# Cliffe Lane, GOMERSAL

Design Response  
January 2024

The purpose of this document is to review the planners design comments and their concerns raised for the proposed site plan layout at Cliffe Lane, Gomersal. This document will address and justify the design rational behind the proposed layout.

HOUSE TYPE G2, 2 STOREY
DETACHED, 4BED, 7PERSON = PLOT
35

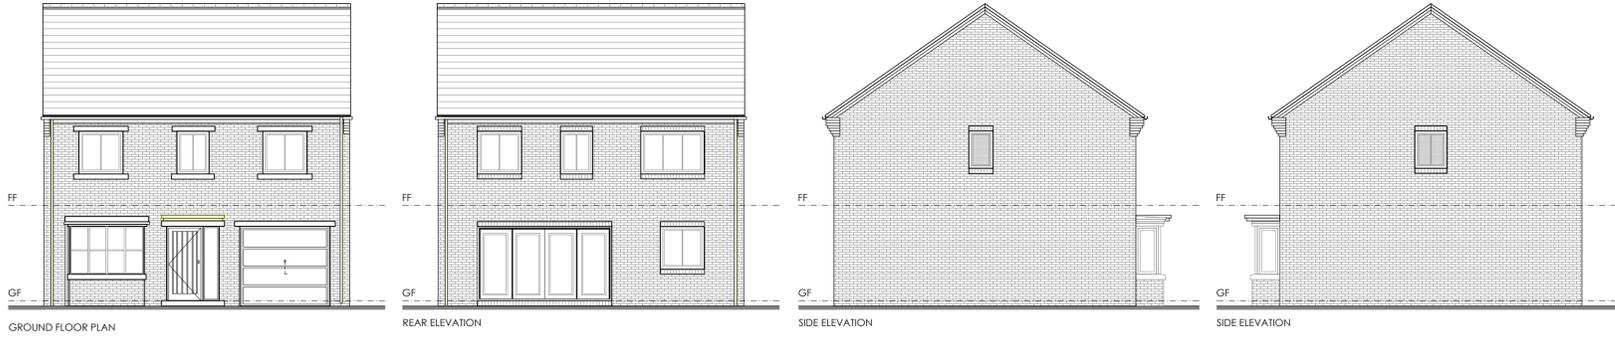
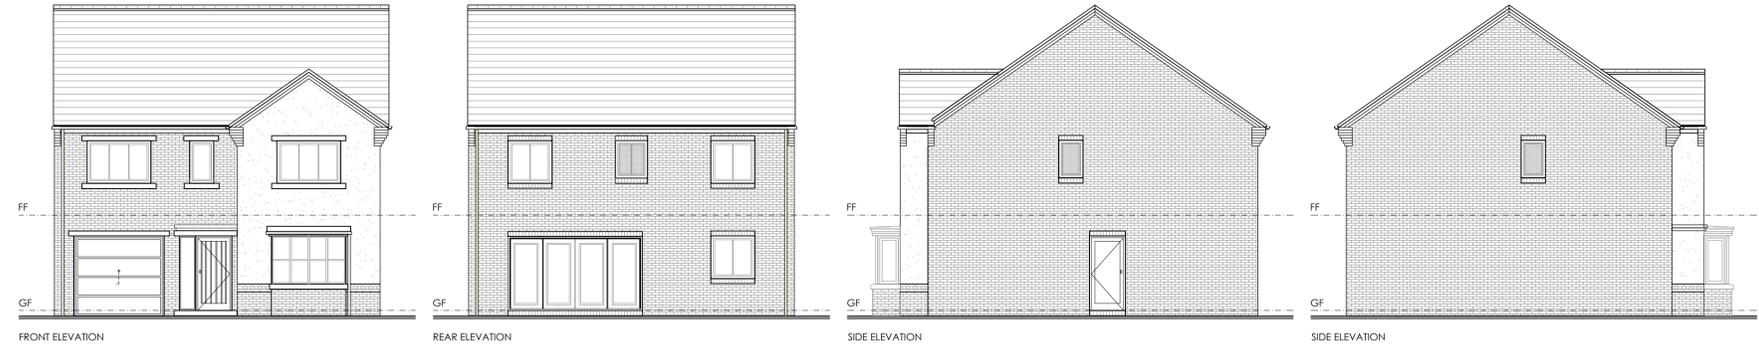
Rotating plot 35 can be achieved with some minor alterations to the plots externals and creating a bespoke house type, by re-designing the kitchen, dining and sitting area. The overlays presented below shows the extents of the changes to achieve the suggestions as per comments by the planners.

Presented below are the new locations of plot 35 and substation. Plot 35 has turned 90 degrees anti-clockwise to face the access roads and has introduced a better outlook. Between plots 1 and 35, these plot proposed a welcoming gateway in to site for residents and visitors.

HOUSE TYPE G2 - BESPOKE, 2 STOREY DETACHED, 4BED, 7PERSON = PLOT 35

HOUSE TYPE F2 - BESPOKE, 2 STOREY
DETACHED, 4BED, 8PERSON = PLOT
10

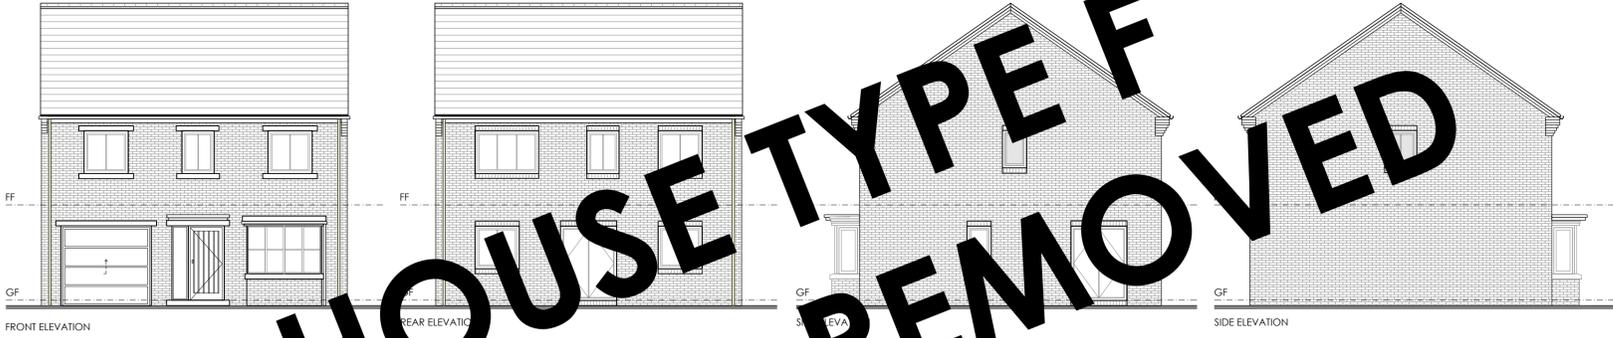
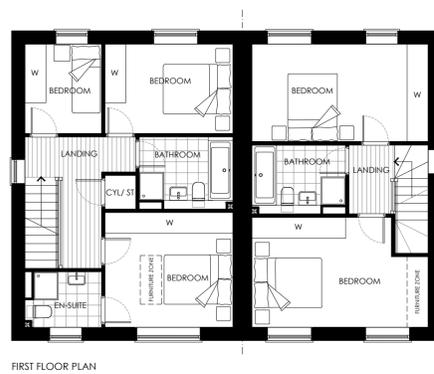
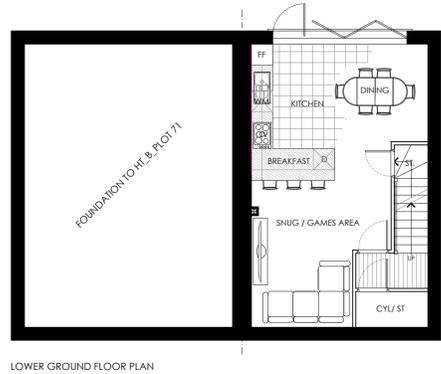
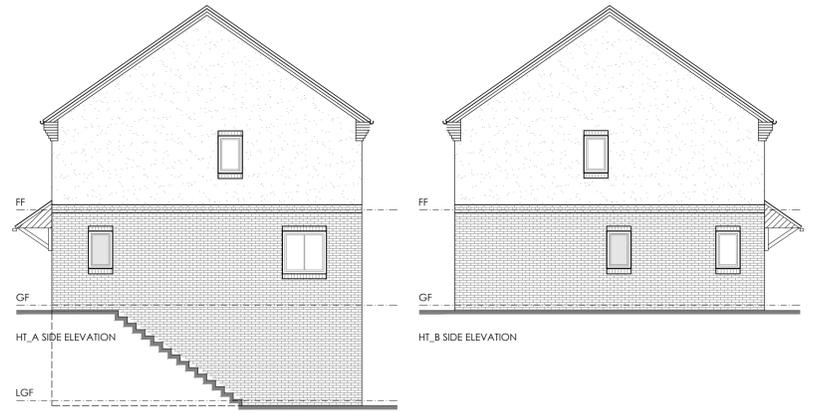
Plot 10's location and orientation is the preferred placement for this dwelling as the plot is surrounded by constraints and the need for retaining walls to make it viable. The existing ground levels influenced the plotting of plots 2 to 10, as shown in the sections presented highlighting a stepped streetscape.

A positive outlook over the pos can still be achieved by retaining the same placement of the dwelling (plot 10) as currently shown on 1694-101\_rev i. by re-designing the kitchen, dining and sitting area. These updates will provide more natural sever lance to the public open space.

As previously mentioned the splits via the party walls has help with levels, mainly on the longer streetscape run. Refining the level across the site has also removed some garden retaining wall in rear gardens. However some may need to be reviewed on site during construction.

HOUSE TYPE F2 - BESPOKE 2 STOREY  
DETACHED\_4BED\_8PERSON = PLOT  
10
